Please ask for: Mrs D Johnson
Email: daun.johnson@arun.gov.uk
Telephone: 01903 737762
Our Ref: A/3/21/PL
Your Ref:
Date: 13th January 2021

Application for Planning Permission

Development: Erection of a 74-bed care home (C2 residential institution) with car parking, landscaped gardens & access from Roundstone Lane. (resubmission following A/9/19/PL). This site is in CIL Zone 2 (Zero Rated) as other development.
Location: Pound Place Roundstone Lane Angmering BN16 4AL

EAST (Sectional) ELEVATION 1- to rear of central wing

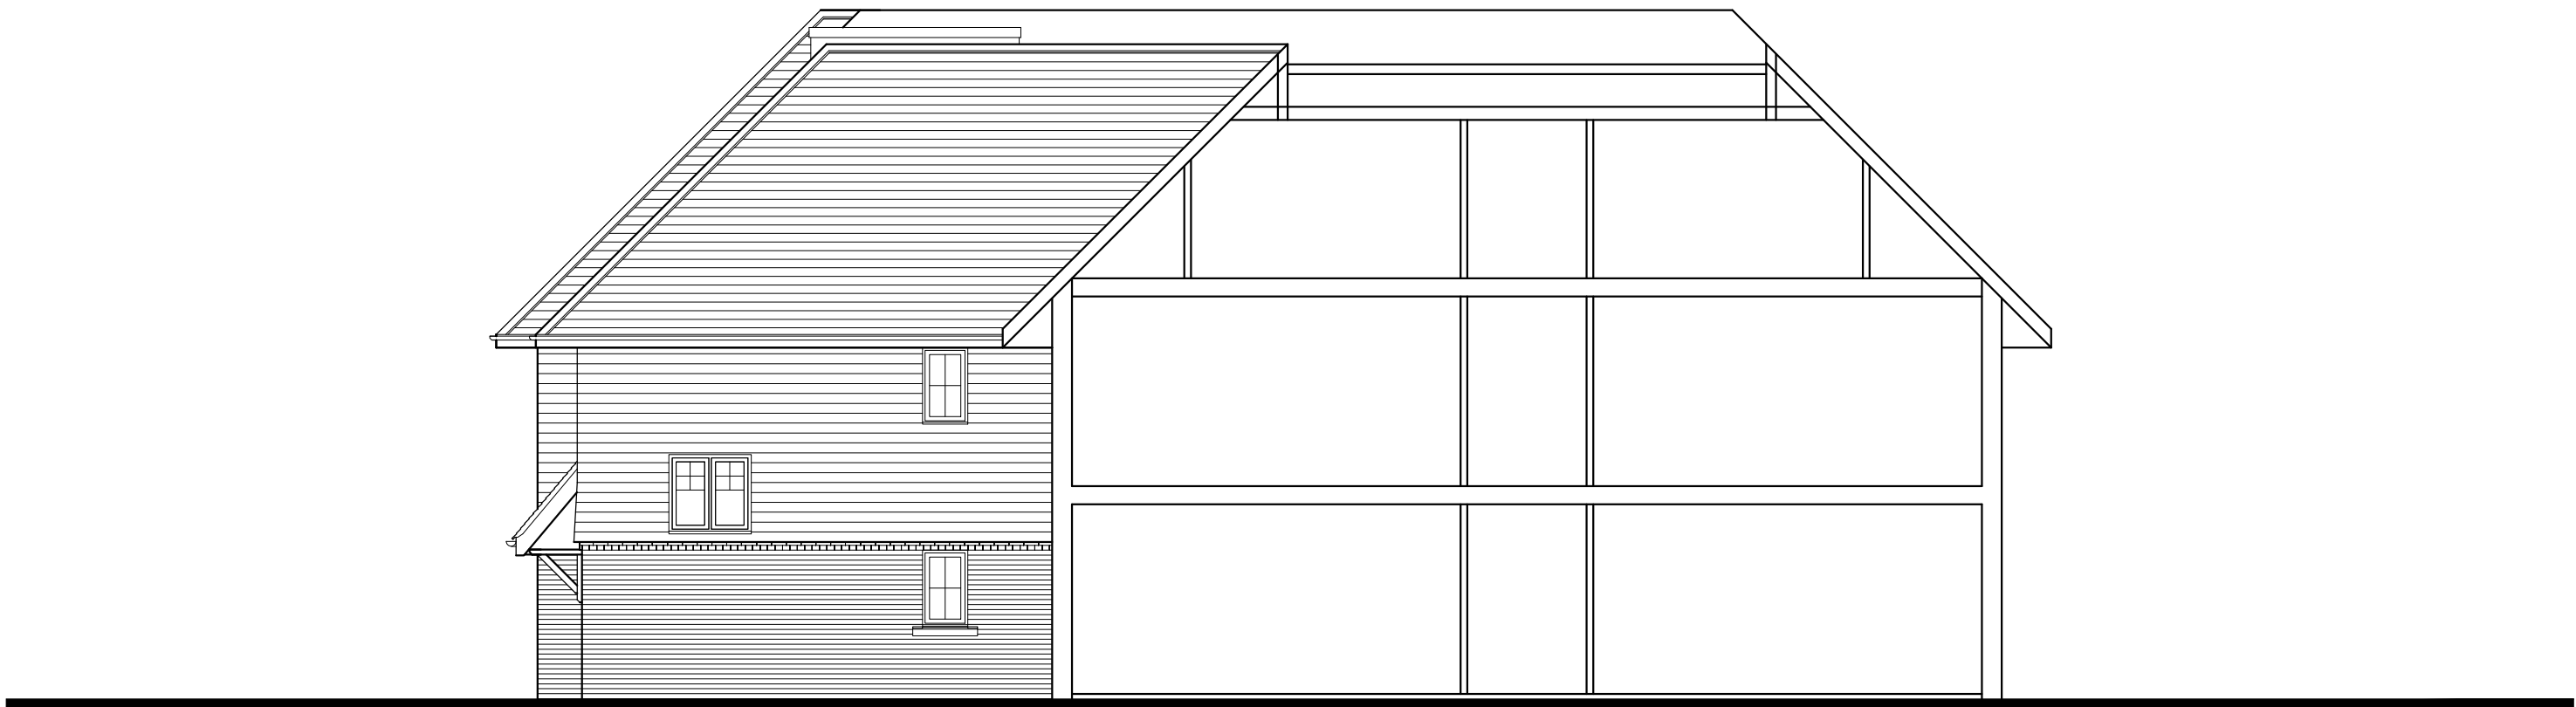
The proposed ground floor plan and East elevation do not accord. Please amend accordingly.

SECOND FLOOR PLAN

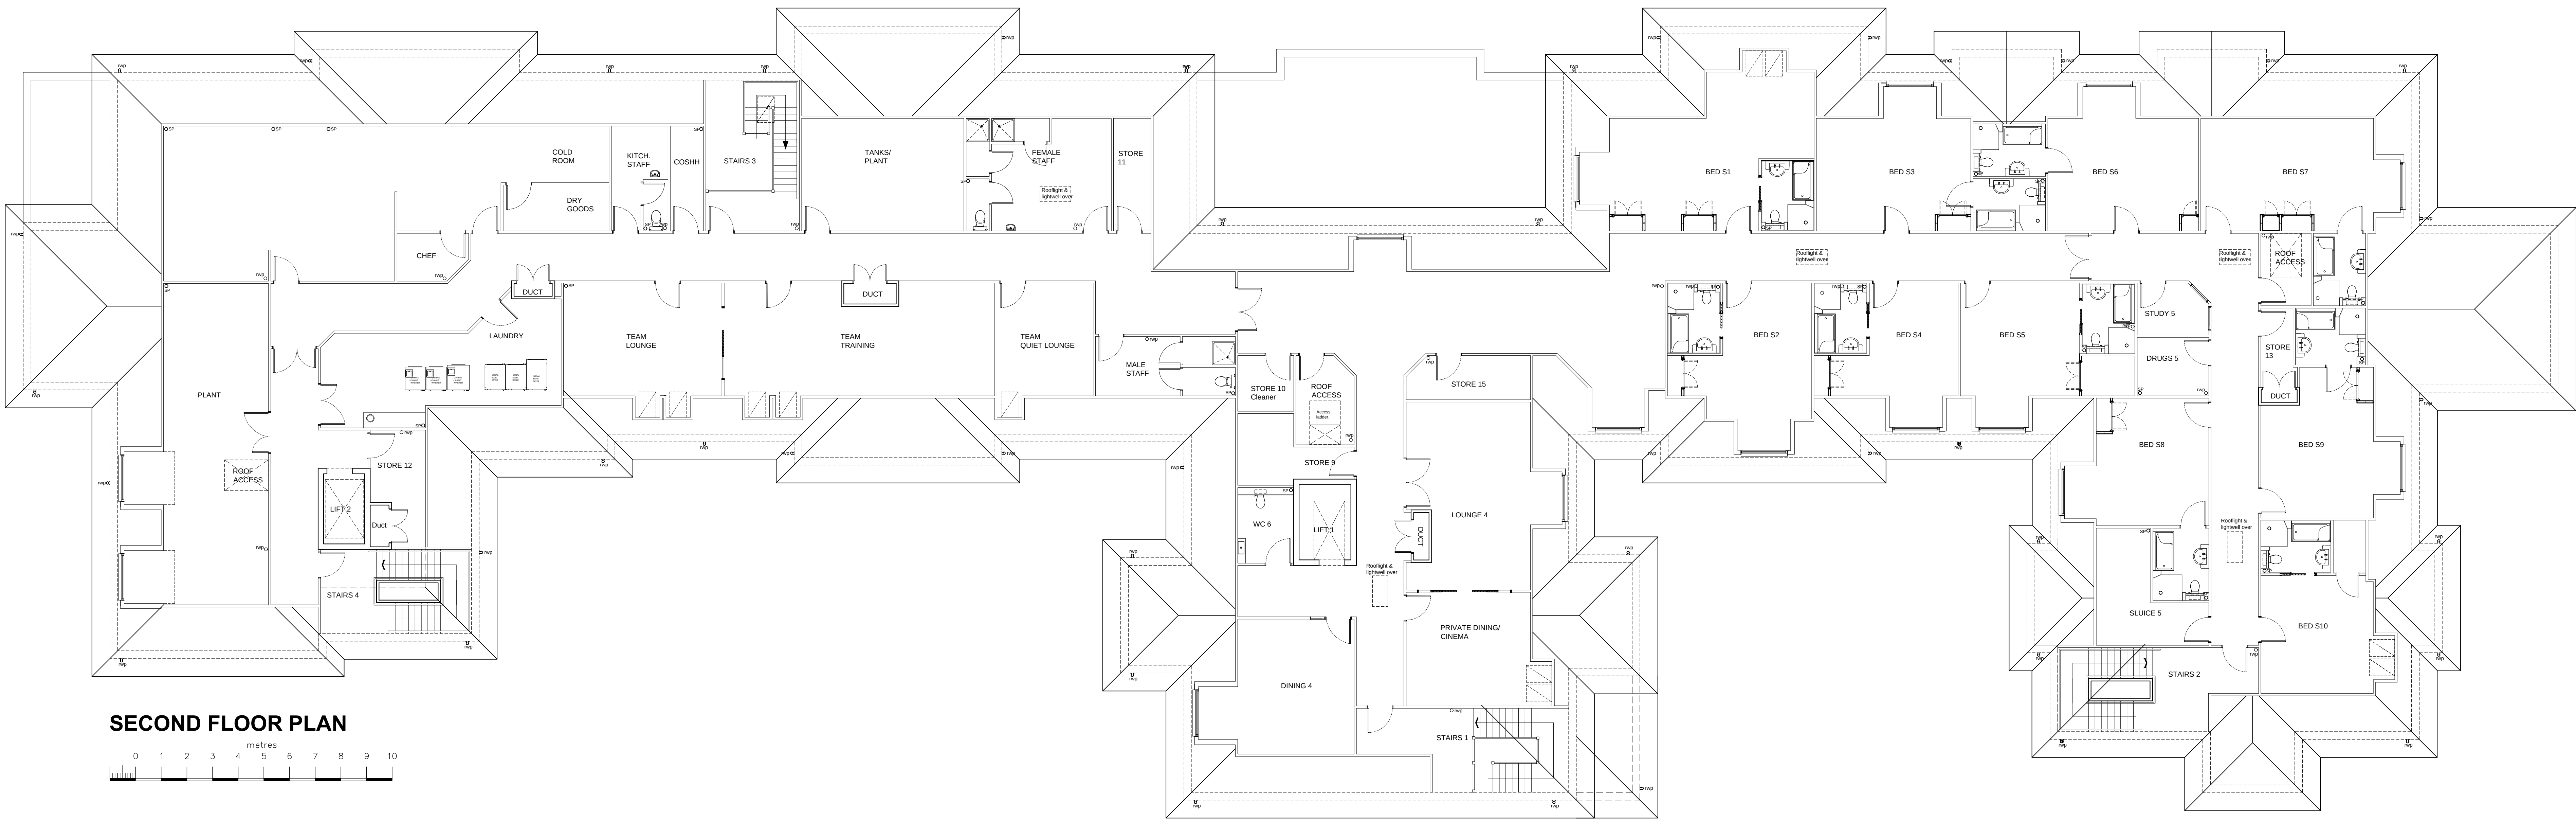
The proposed second floor plan and North elevation do not accord. Please amend accordingly.
